City of Ryde Submission 6-8 Julius Avenue North Ryde - SSDA Julius Avenue Data Centre

SSD-80018208

**Submission Date: 27 August 2025
COR2025/262/1**

East Elevation

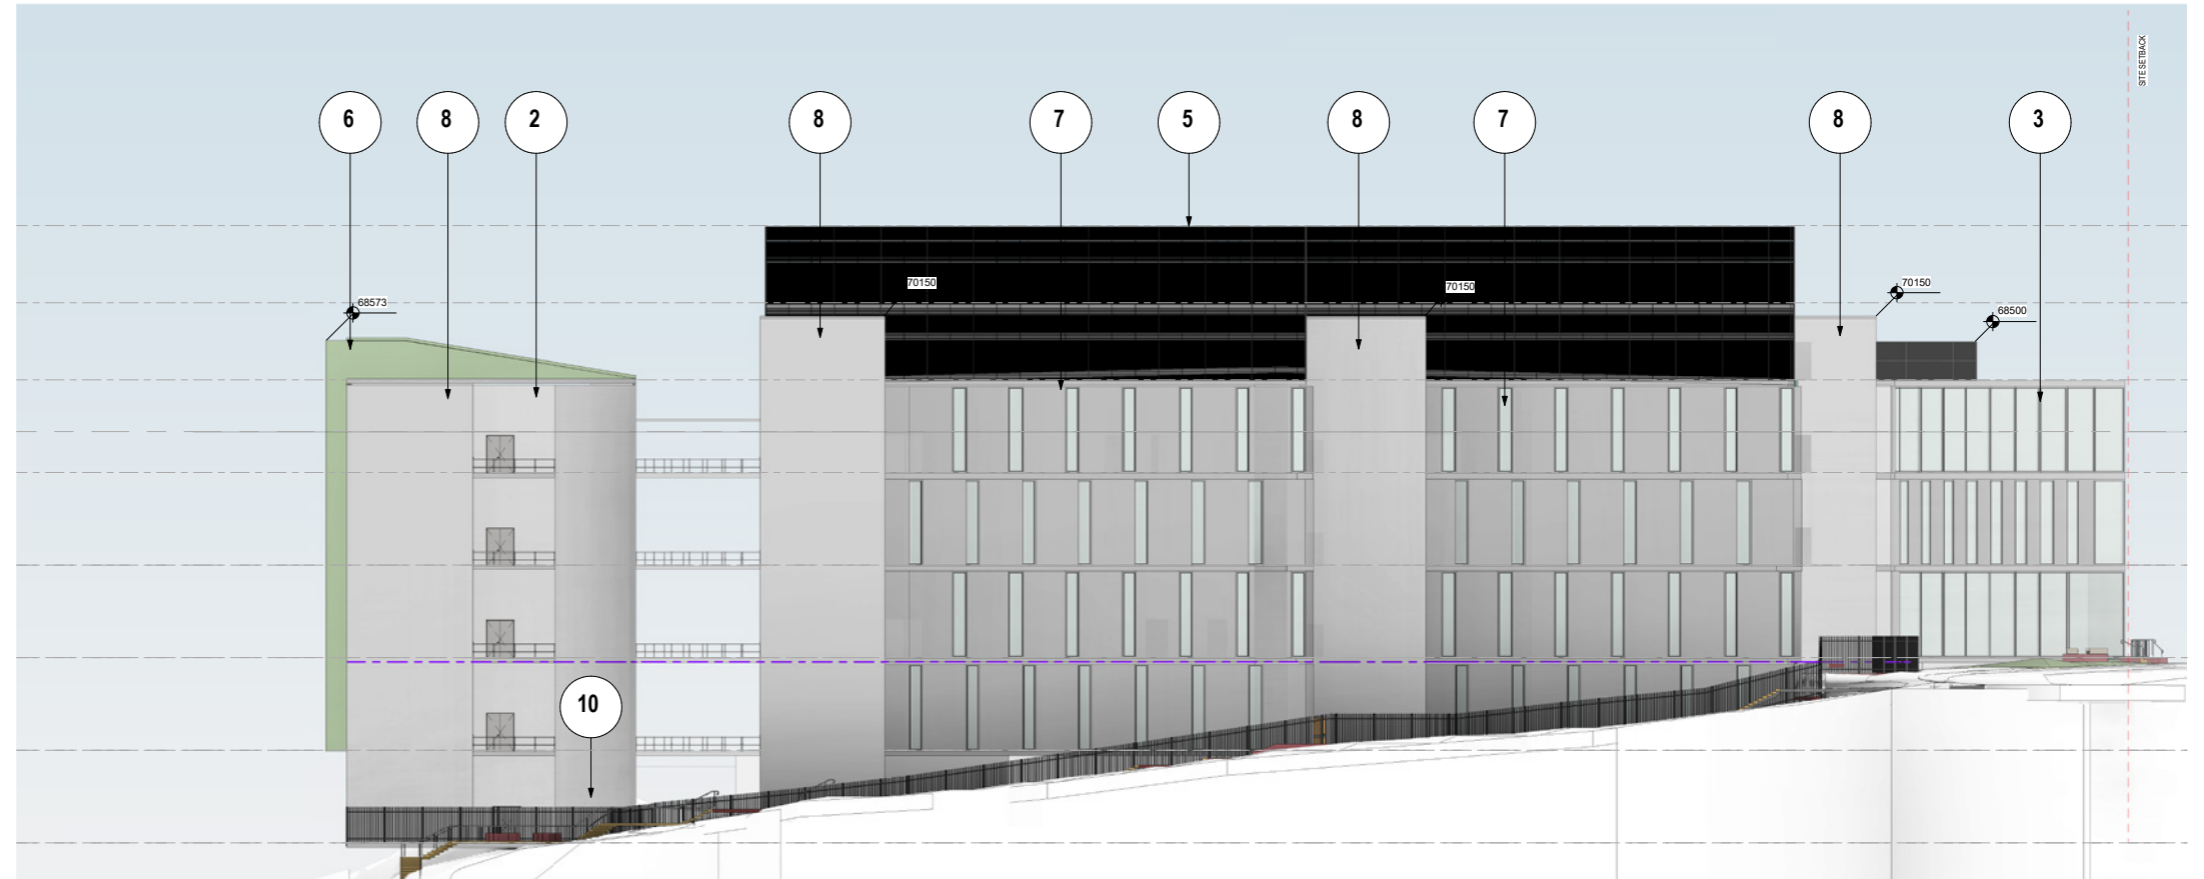
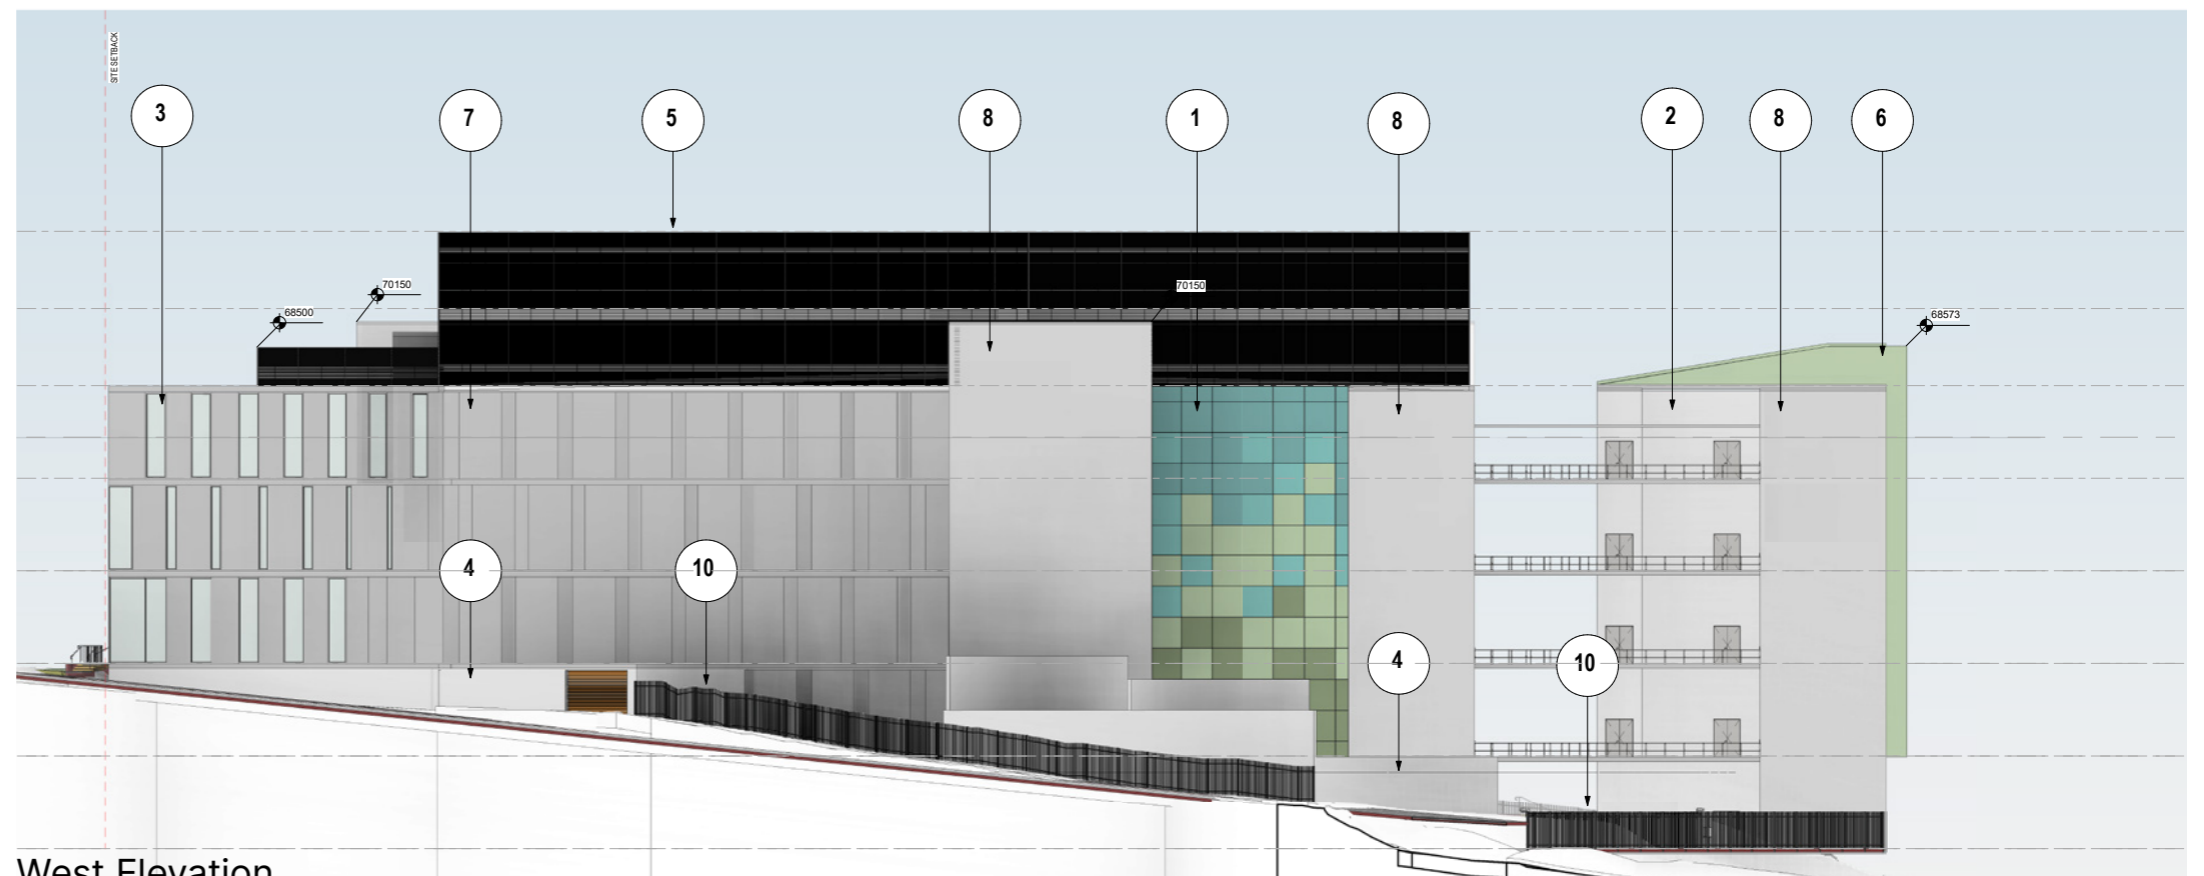
The façade design strategy and material selection should respond to the local character and context. Council is concerned that the reflectivity of the proposed polished metal cladding on the expansive blank wall along the Julius Avenue may negatively impact on the neighbouring buildings as well as car drivers and pedestrians. Additionally, the western façade with the same material is likely to affect the building at 10 Julius Avenue

It is recommended that the applicant revisit the façade strategy and material selection to ensure a contextually responsive design outcome, mitigate visual impacts, and reduce the risks associated with reflectivity. Any RtS response should include a reflectivity assessment to demonstrate the proposed façade is suitable.
